Phone: 0300 123 6780
Email: developeras@lancashire.gov.uk
Your ref: 3/2023/0692
Our ref: D3/2023/0692
Date: 22 September 2023

Planning Application No: 3/2023/0692

Proposal: Proposed single-storey side extension to existing holiday let property.

Location: Bowland Forest Farm, Settle Road, Bolton By Bowland BD23 4SN

Title: Bowland Forest Farm Masterplan
Amendment A - 25/10/23 - Boundary alterations

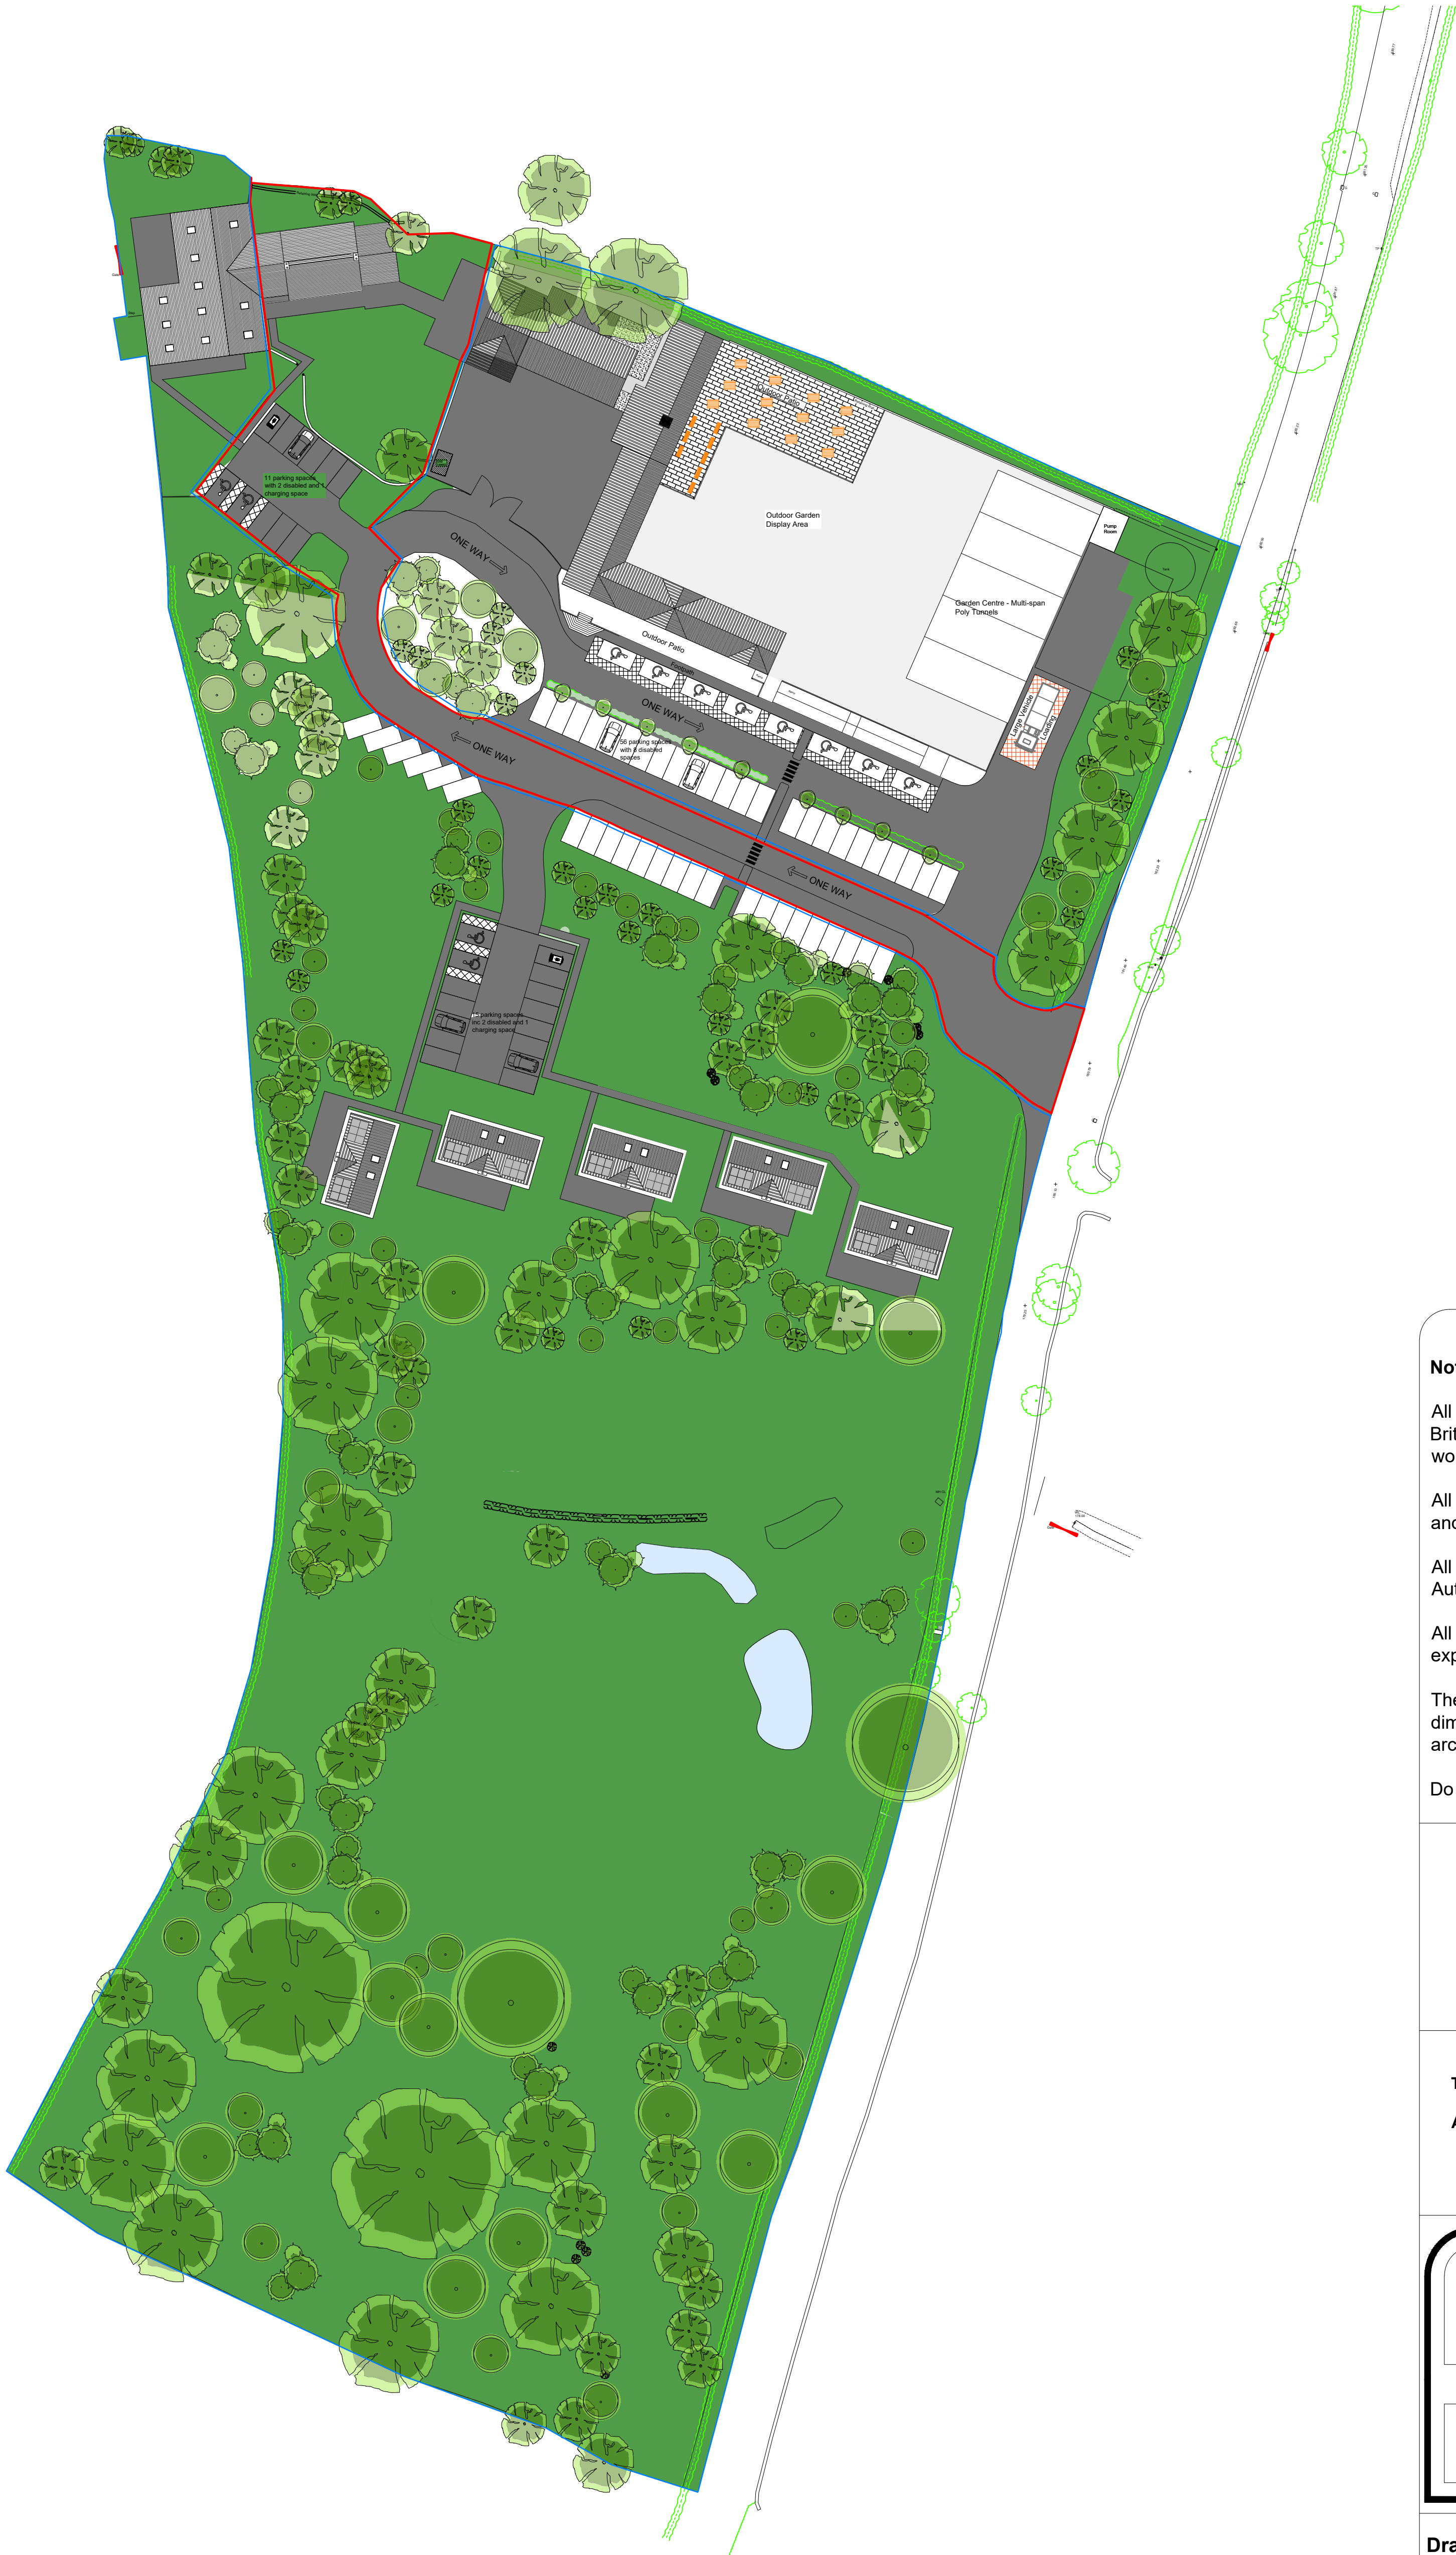
However, as two accessible ground floor bedrooms are now proposed the two mobility spaces should be re-located closer to the building and adjacent to the footway. The space for the vehicle charging would also have to be re-located.

In addition, the footway from the car parking spaces to the front entrance should also be widened to a minimum of 1.5m to allow a wheelchair user and ambulant person to walk side by side ('Inclusive Mobility' section 2.2).

An amended plan should be submitted taking the above into account.
